The Secretary  
NSW Department of Planning, Industry & Environment

4 February 2022

I refer to the Department's below email of 1 February 2022 regarding the Environmental Impact Statement (EIS) for State Significant Development SSD-17899480 for the Wentworthville Northside West Clinic Extension comprising construction of a three-storey extension and a new car park as well as internal and external alterations to the existing building located at 23-27 Lytton Street, Wentworthville (Lot 1 DP 787784) in the Cumberland City Local Government Area (LGA). Submissions need to be made to the Department by 3 March 2022.

Endeavour Energy's further recommendations and comments are as follows:

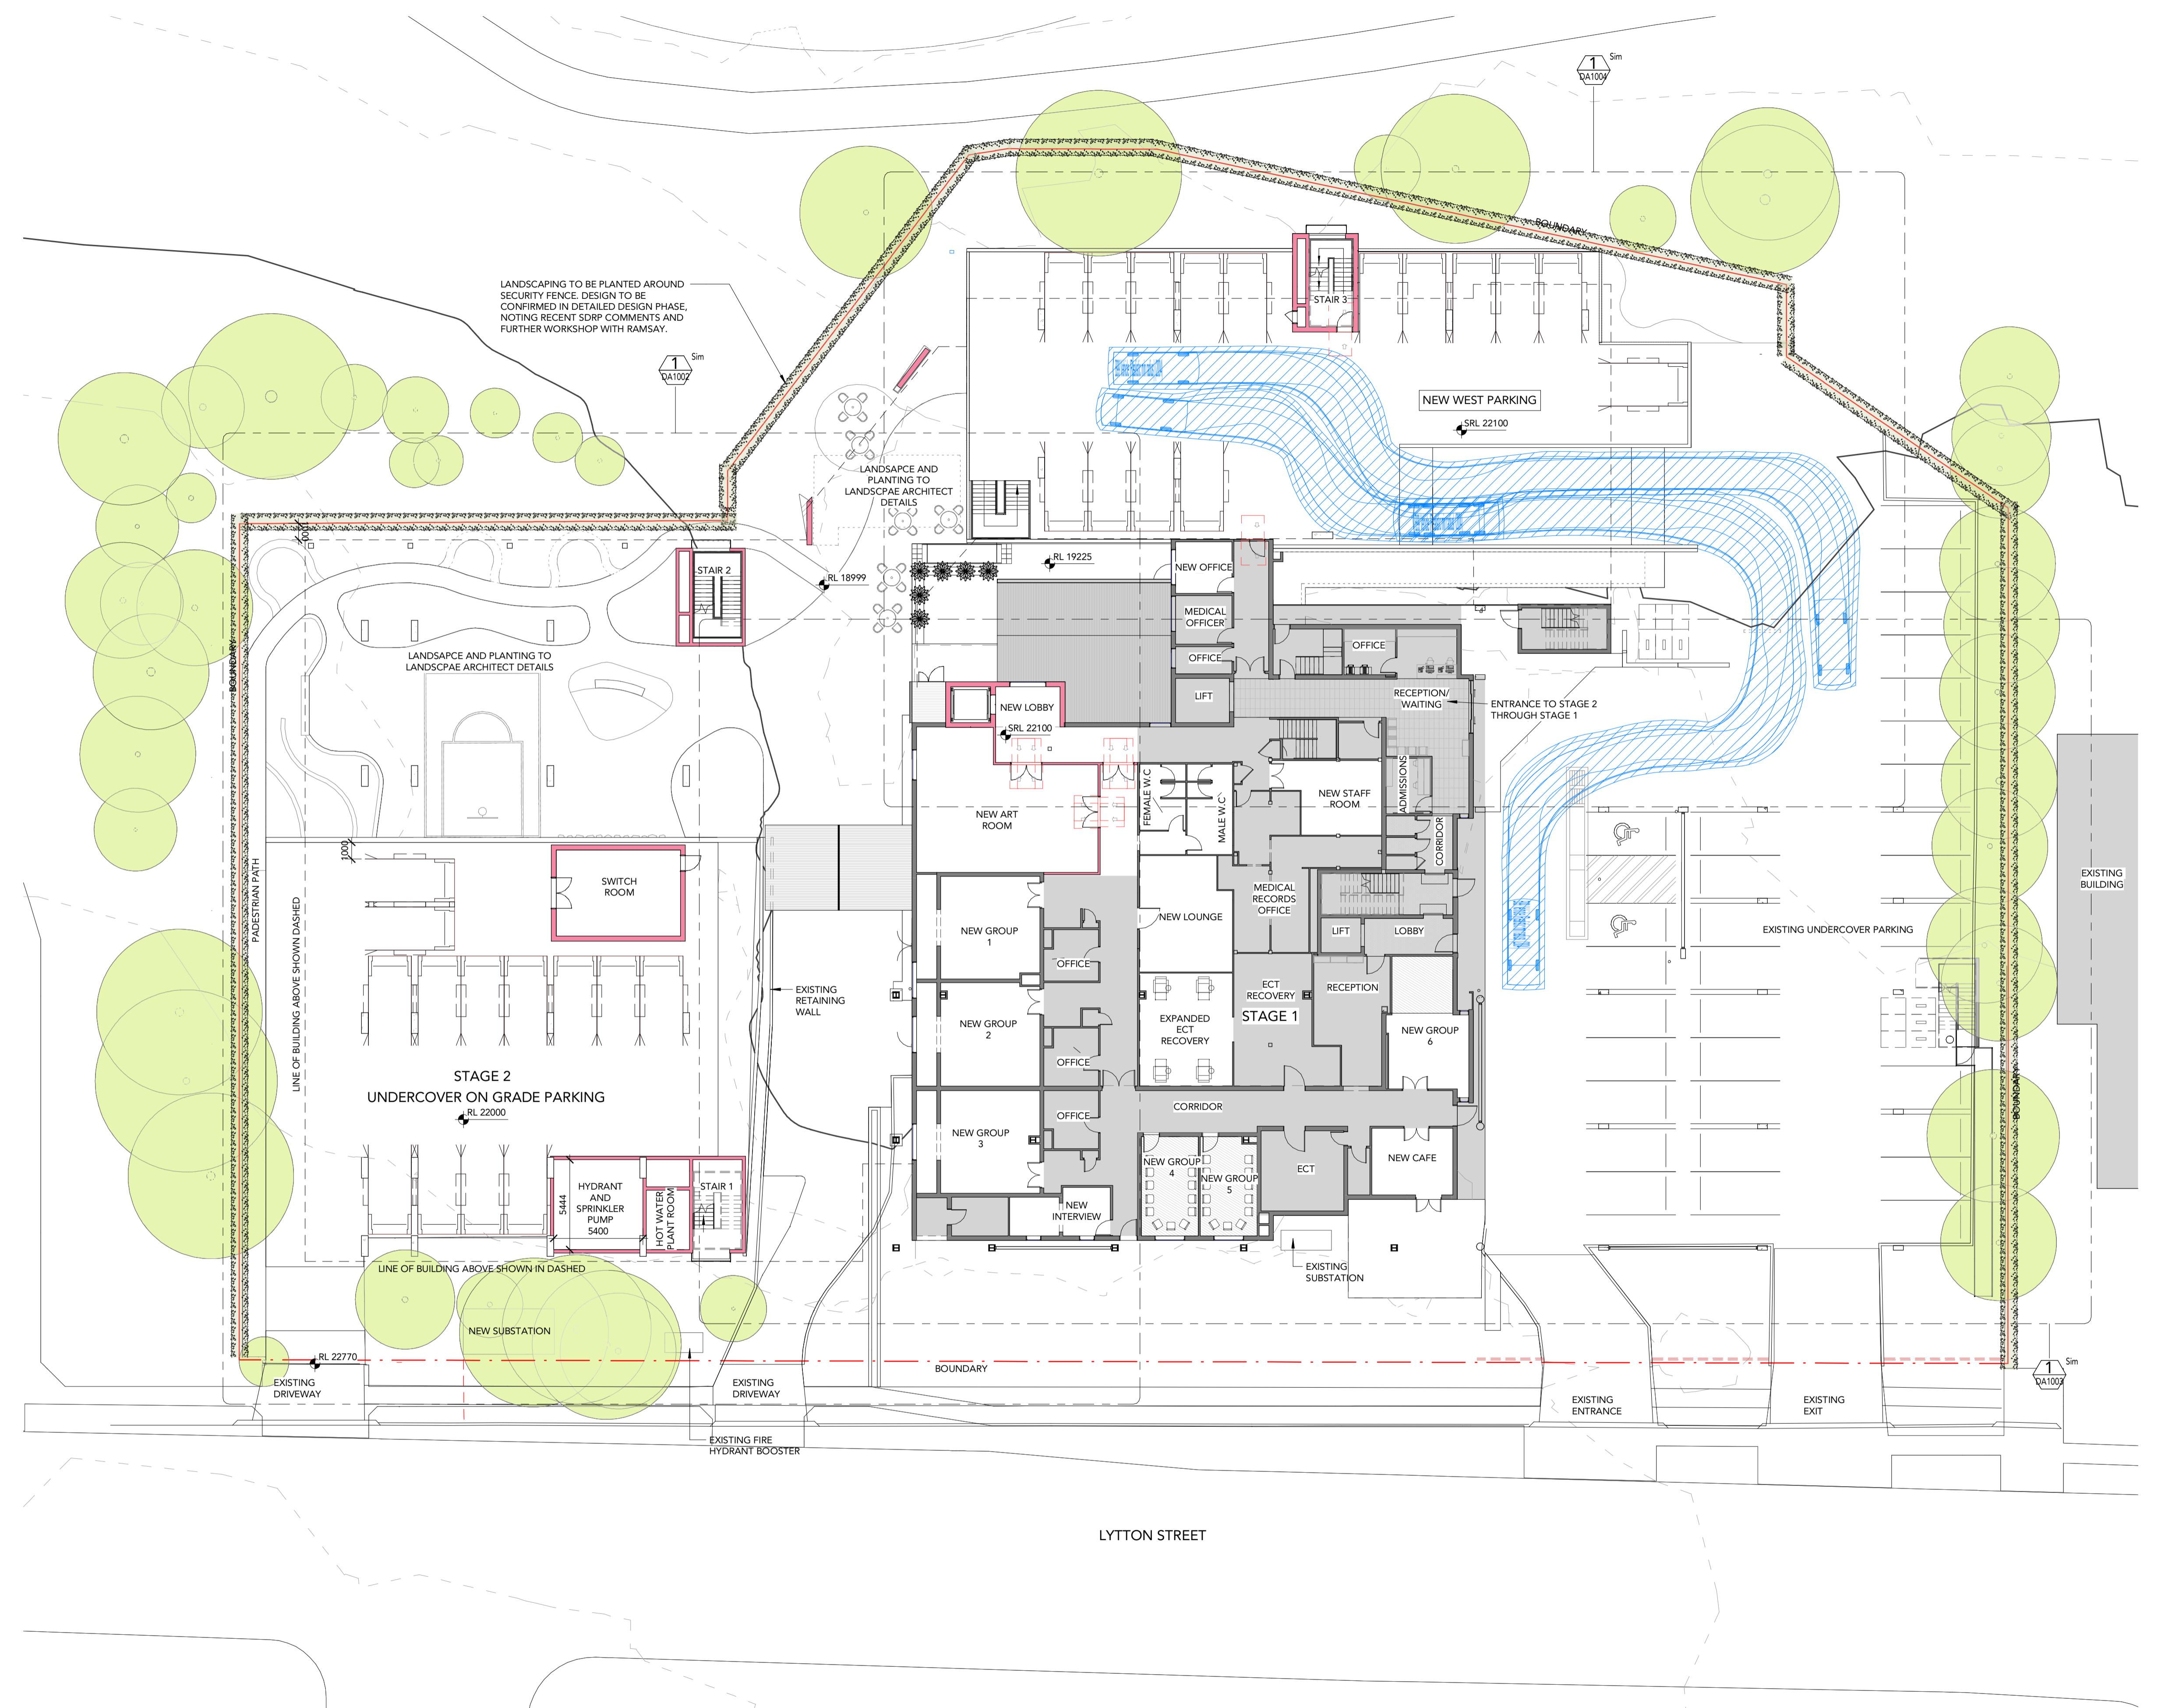
The following extract of the Overall Site Plan – Ground Floor shows provision for a 'New Substation' to the south of the 'Existing Substation' near 'Stage 2 Undercover On Grade Parking'. From Endeavour Energy's perspective the fact that provision is being made for a padmount substation is a positive. Endeavour Energy's general requirements is for a padmount substation to be at ground level and have direct access from a public street (unless provided with appropriate easements for the associated underground cables and right of access). The padmount substation must be protected by an easement and associated restrictions benefiting and gifted to Endeavour Energy. Please refer to Endeavour Energy's Mains Design Instruction MDI 0044 'Easements and Property Tenure Rights'.
